Our Ref: AW/281/18/T

**Town & Country Planning Act 1990 (as amended)
Town & Country Planning (Tree Preservation) (England) Regulations 2012
Application for Consent to Carry Out Works to Tree(s) Protected by Tree Preservation Order**

Development Surgery to 1No. Lombardy Poplar and 1No. Horse Chestnut tree.
Location 25 Rucrofts Close Aldwick Fields

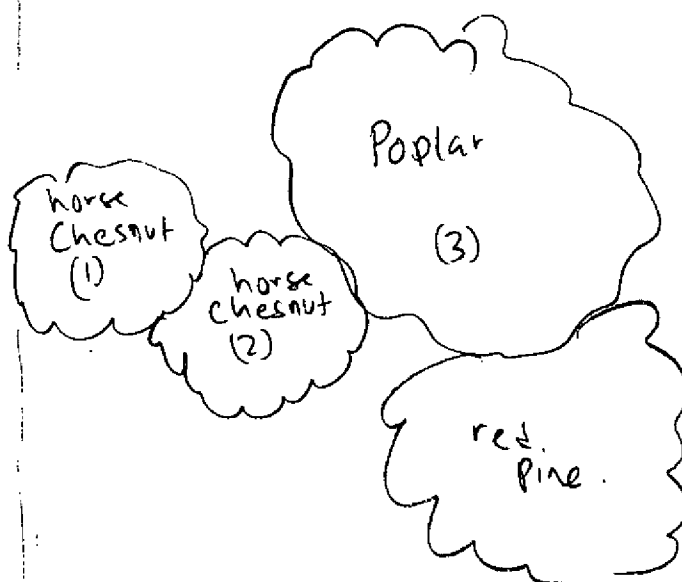
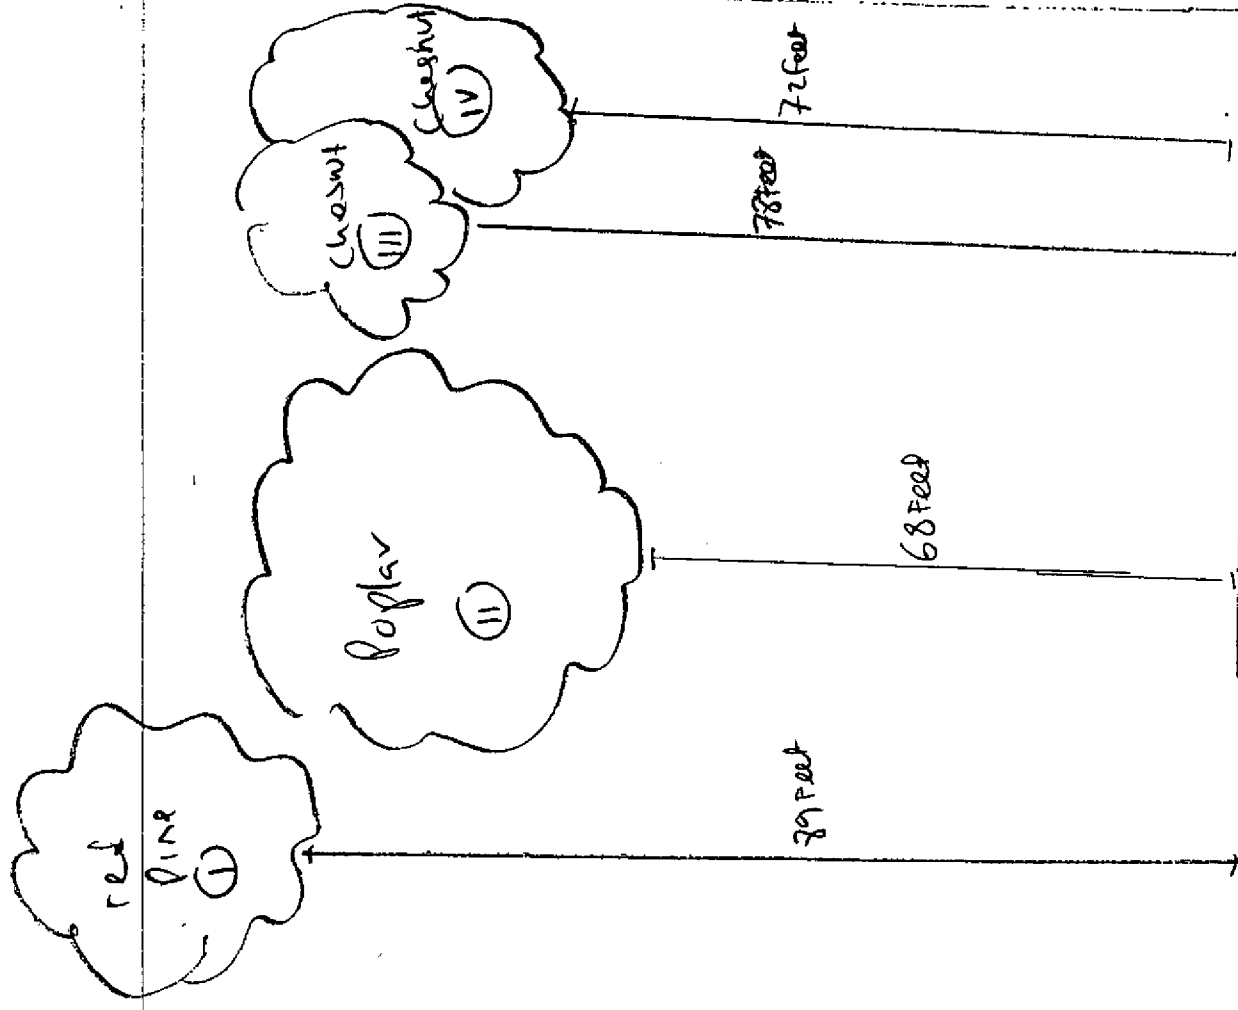
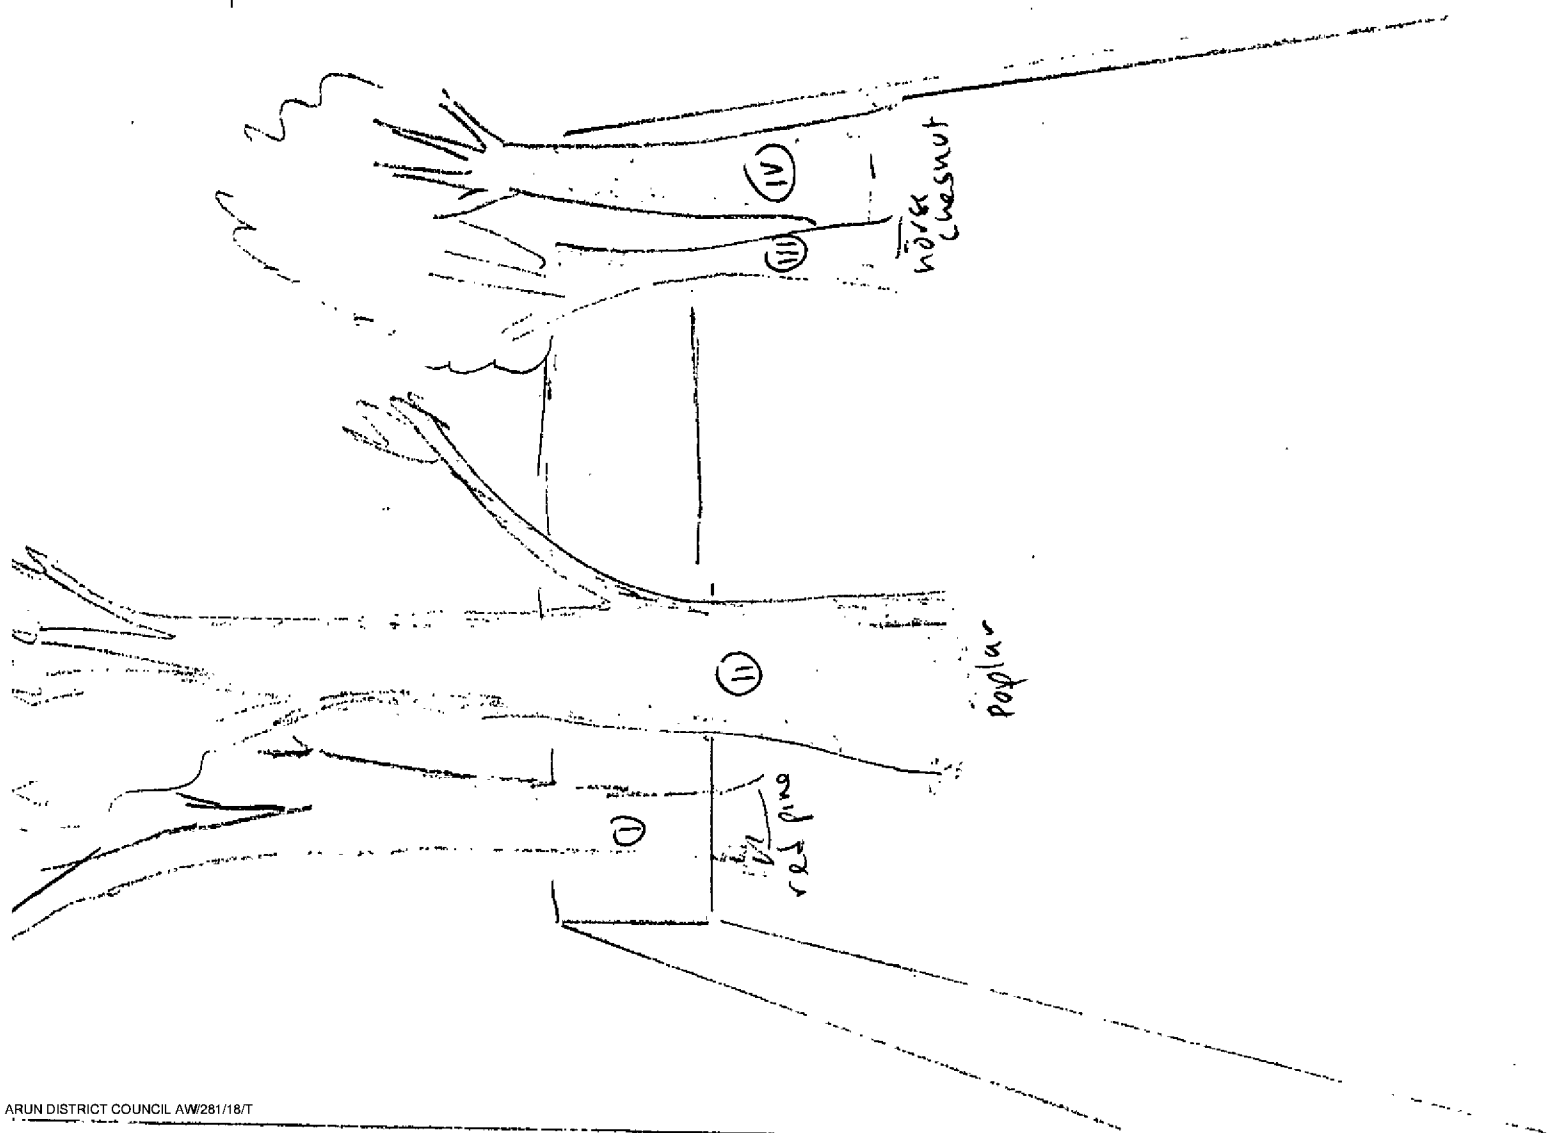
Please highlight which Horse Chesnut tree required thinning.

1No. Lombardy Poplar please advise the height reduction in metres.

1No. Horse Chesnut tree please advise the percentage of crown thin.
